Re: PA22-040 – 87th & 40th PRD – Technical Review 2
4218 / 4112 / 4018 / 3922 / NNA 87th Ave NE

After preliminary review of the above referenced proposal, the following comment(s) are provided:

SHEET OF
C4.02 24
PROJECT NUMBER
21036

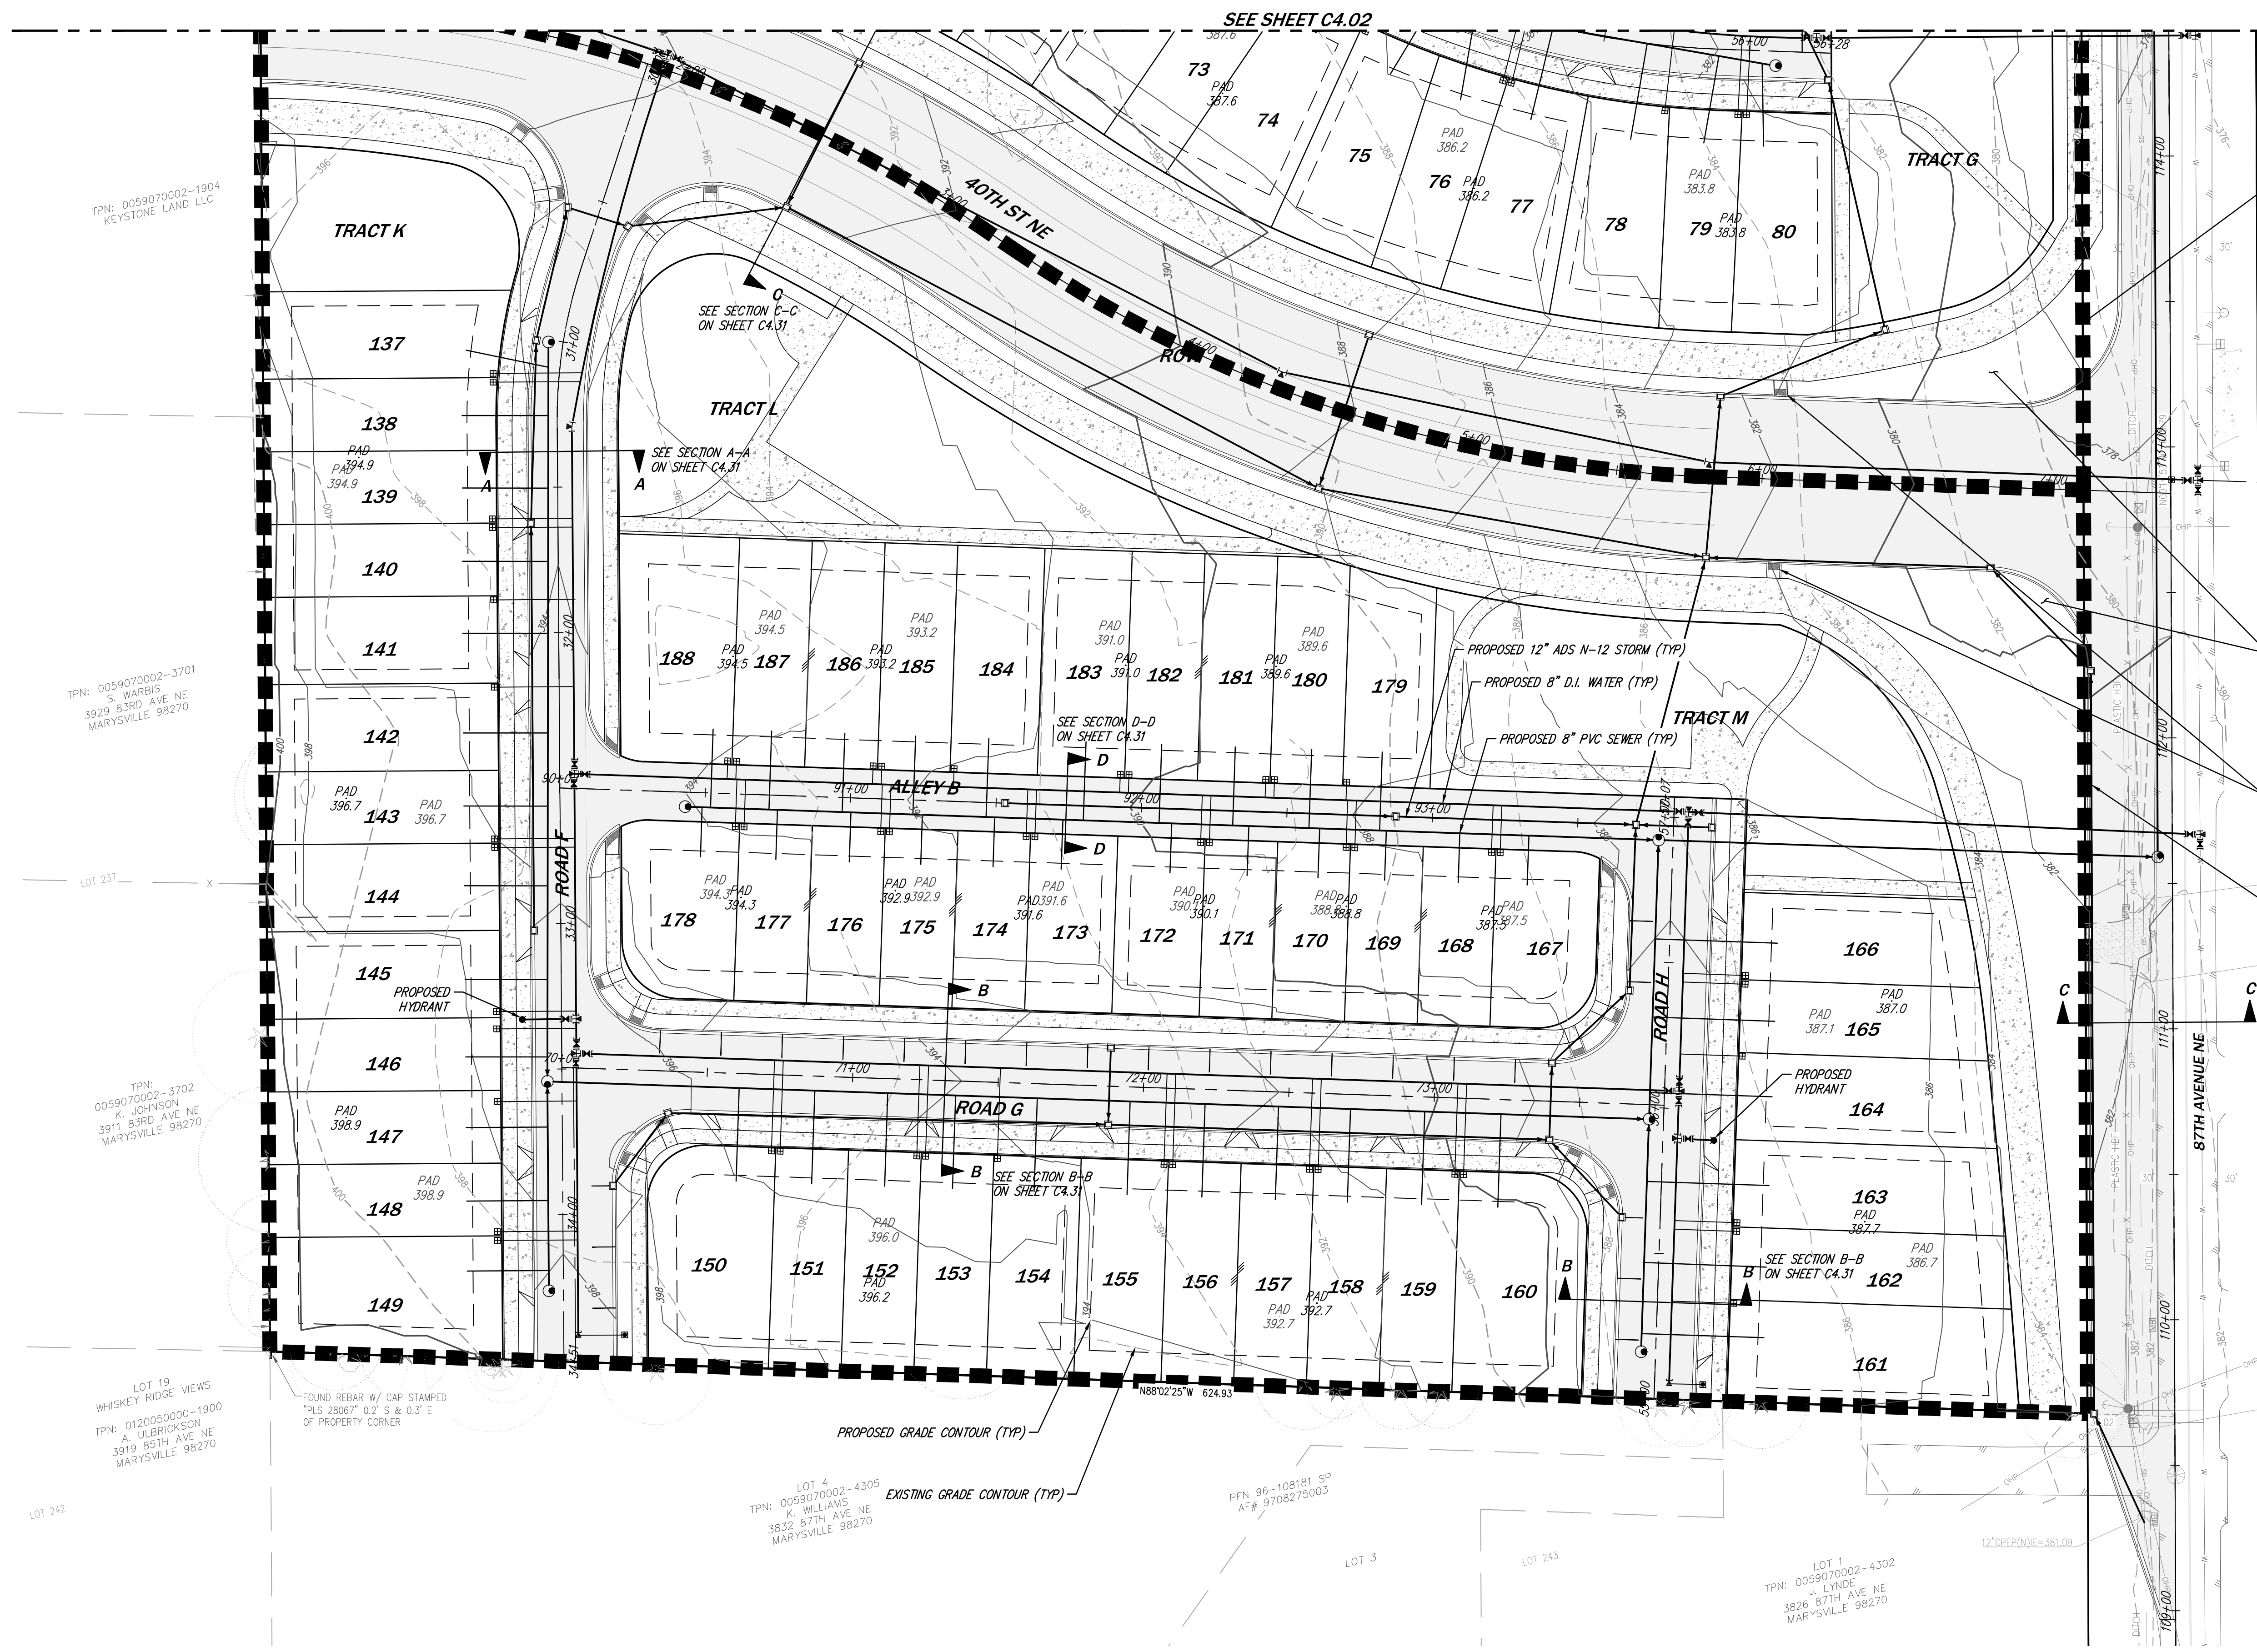
5. **UTILITIES** - We will accept the removal of sanitary sewer along 40th St NE.
 - 5.1. I am unsure as to what sewer main along 85th Ave NE comment number 5 in the response letter from Michael Reid is referring to? It appears that the most recent revised preliminary civil plans shows the sewer main along 85th Ave NE. Was comment #5 an error or are the plans not correct?

- 5.2. We will also accept the removal of the water main along 85th Ave NE and pulling the individual water services off of Road B and Road A.
6. **FRONTAGE IMPROVEMENTS** - Frontage improvements are required per MMC 12.02A.090 on all projects. Frontage improvements are described as curbs, gutters, and sidewalks; underground storm drainage facilities; patching the street from its preexisting edge to the new curb line; and overlayment of the existing public street to its centerline.

DATE	AUGUST 2022
DESIGNED	DANIEL BABA
DRAWN	CHUCK FEMLING
APPROVED	MICHAEL L. MATHESON
PROJECT MANAGER	BEN MADEO, AICP
SHEET	OF
C4.31	24
PROJECT NUMBER	21036

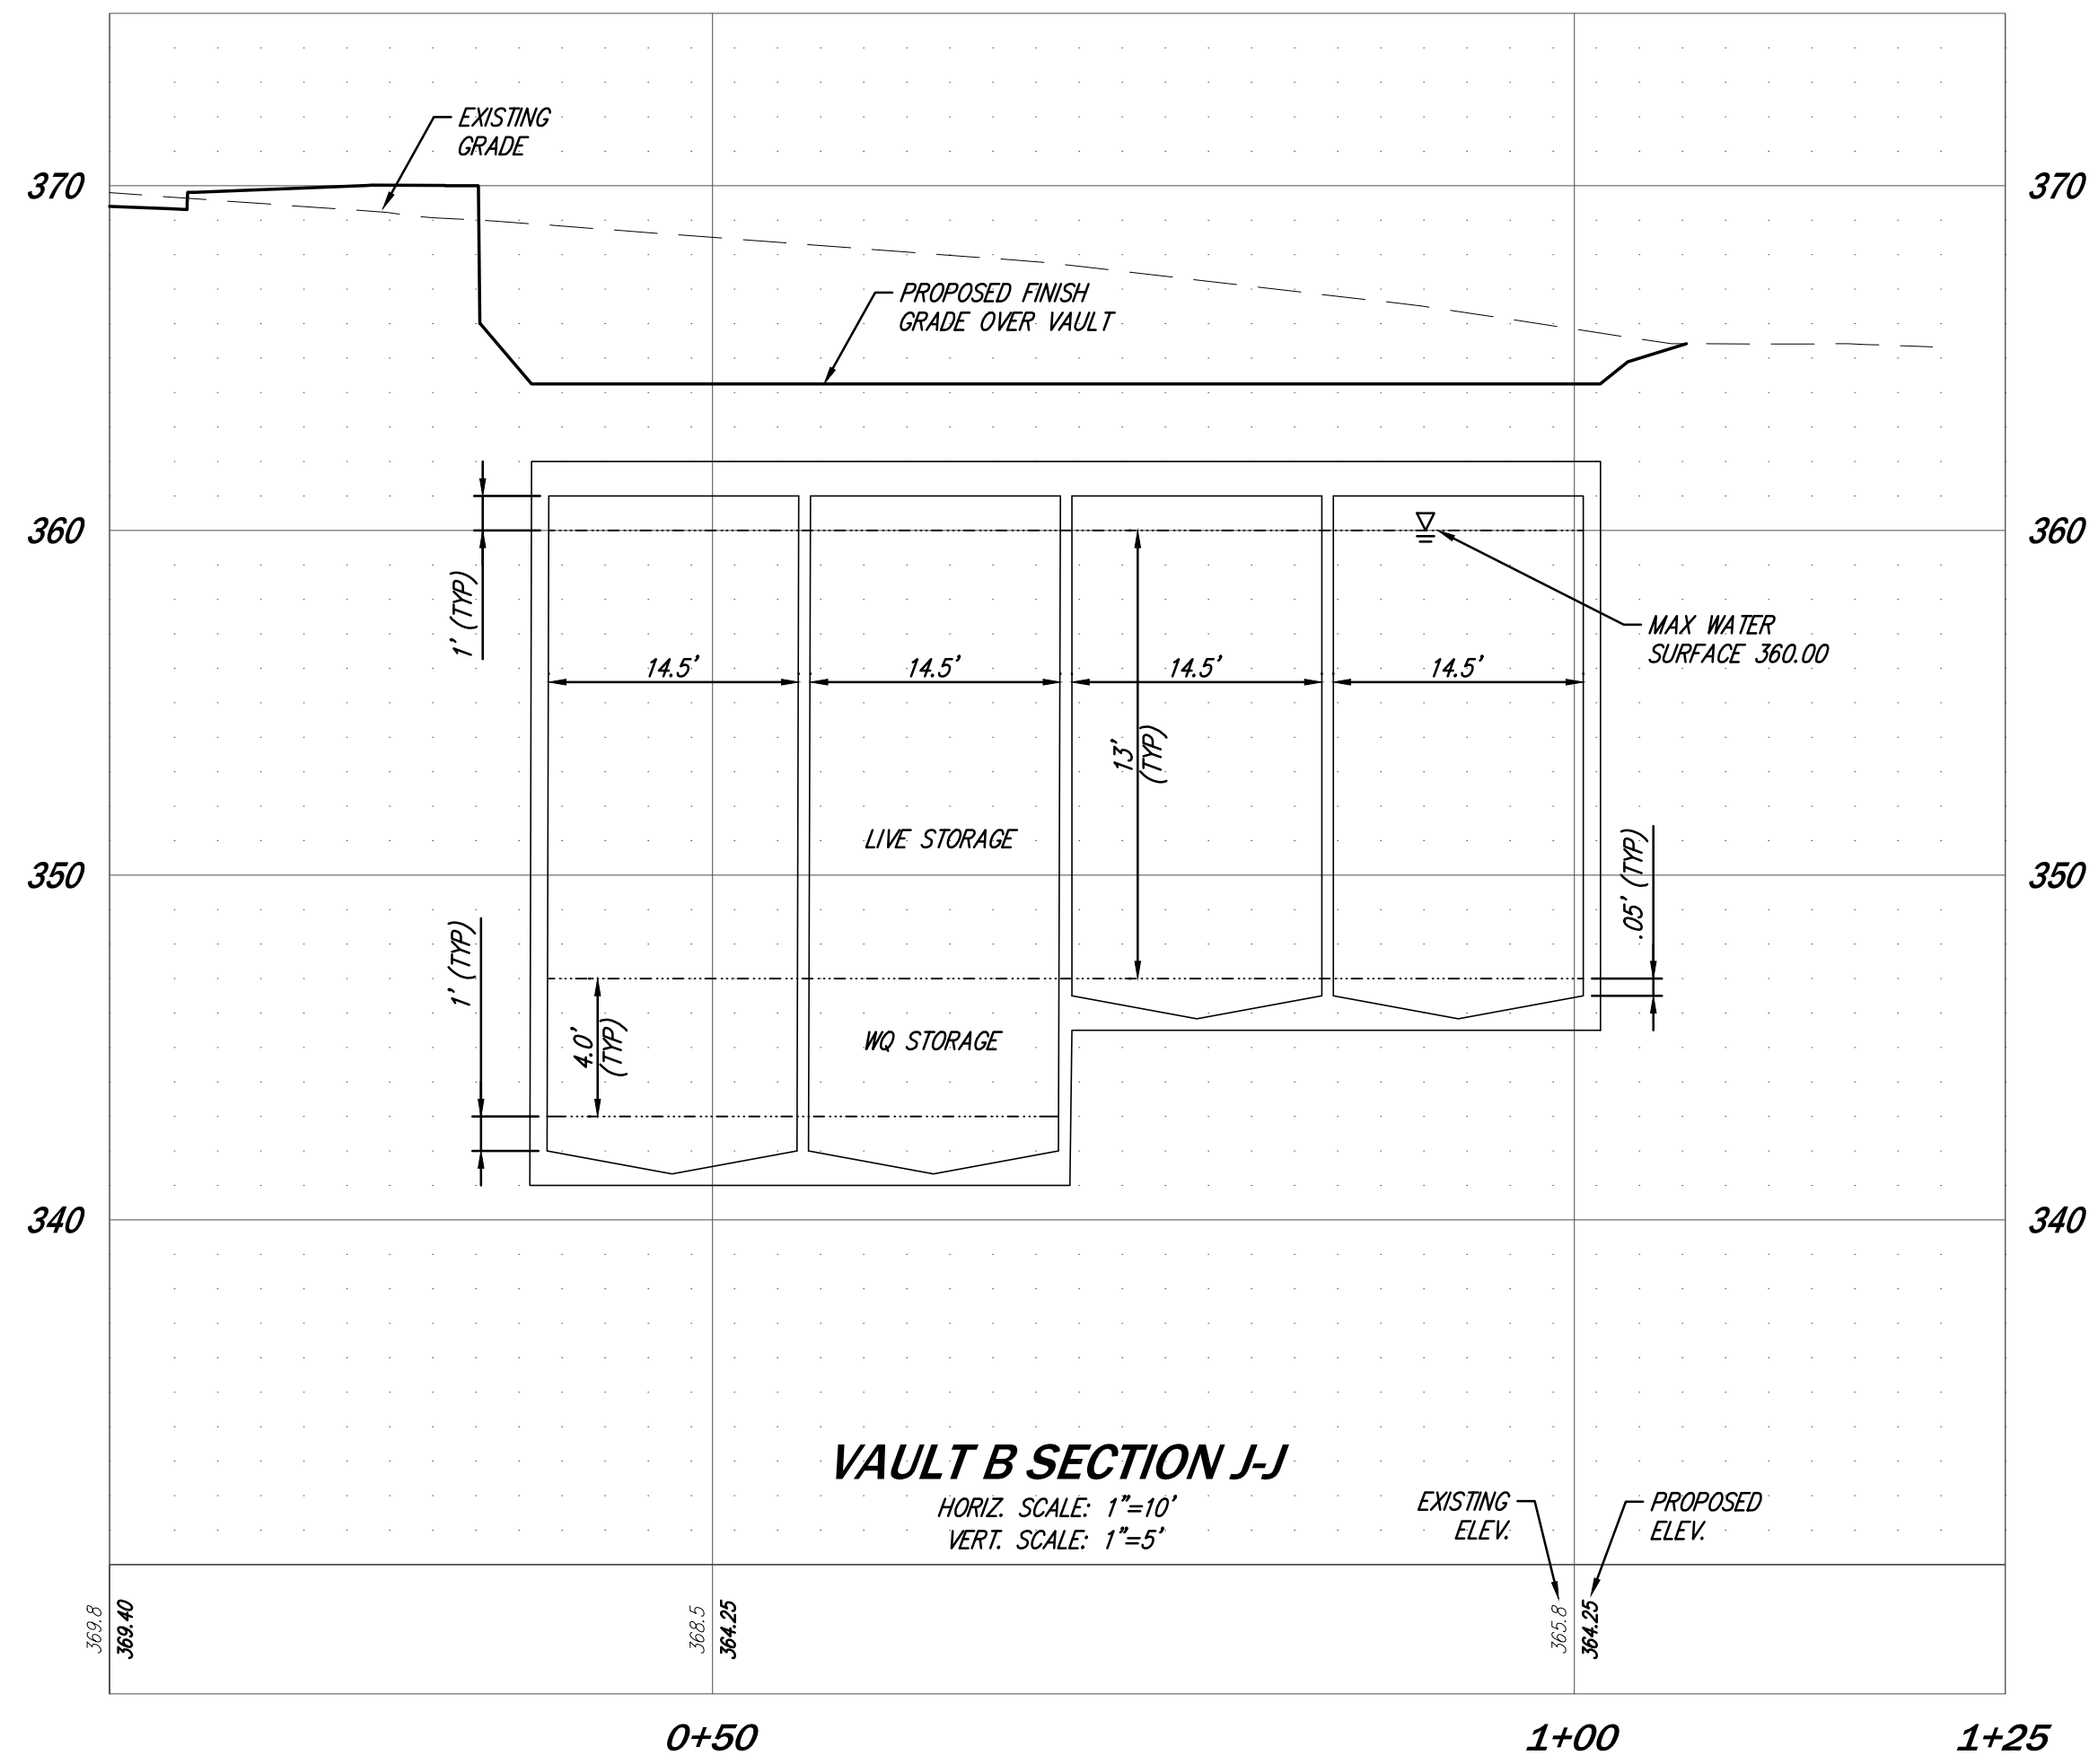
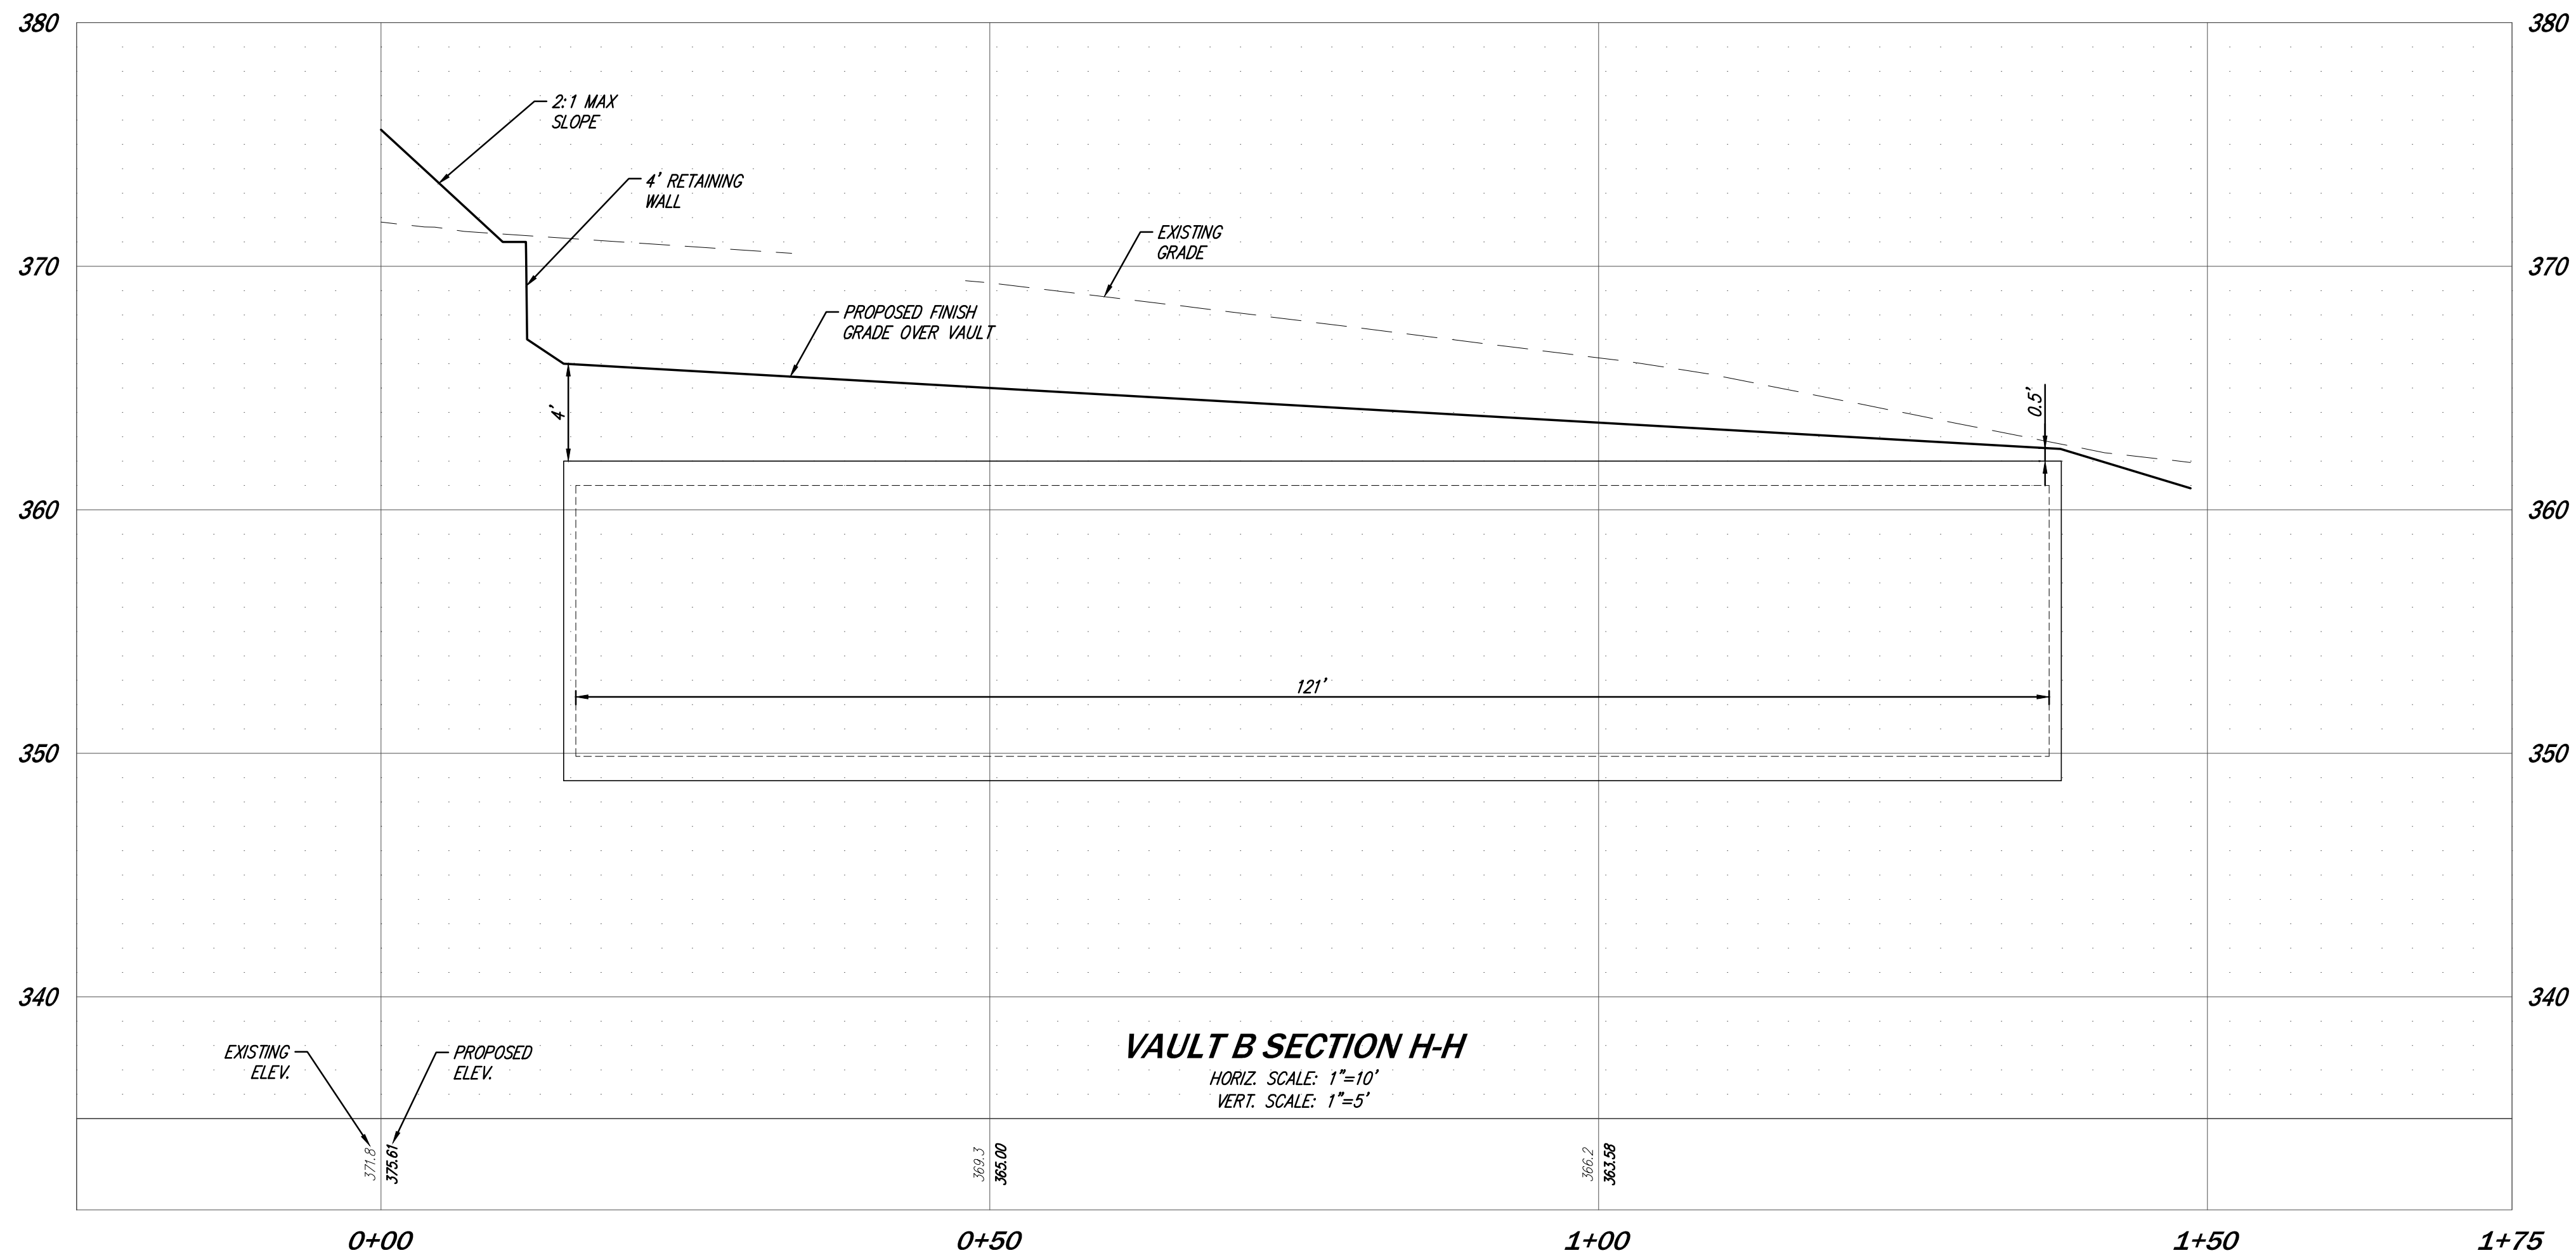
- 6.1. We will be requiring 40th St NE to be built out to full road section SP 3-201-002 with a 12 ft. multi-use trail from 87th Ave NE to the western property boundary.
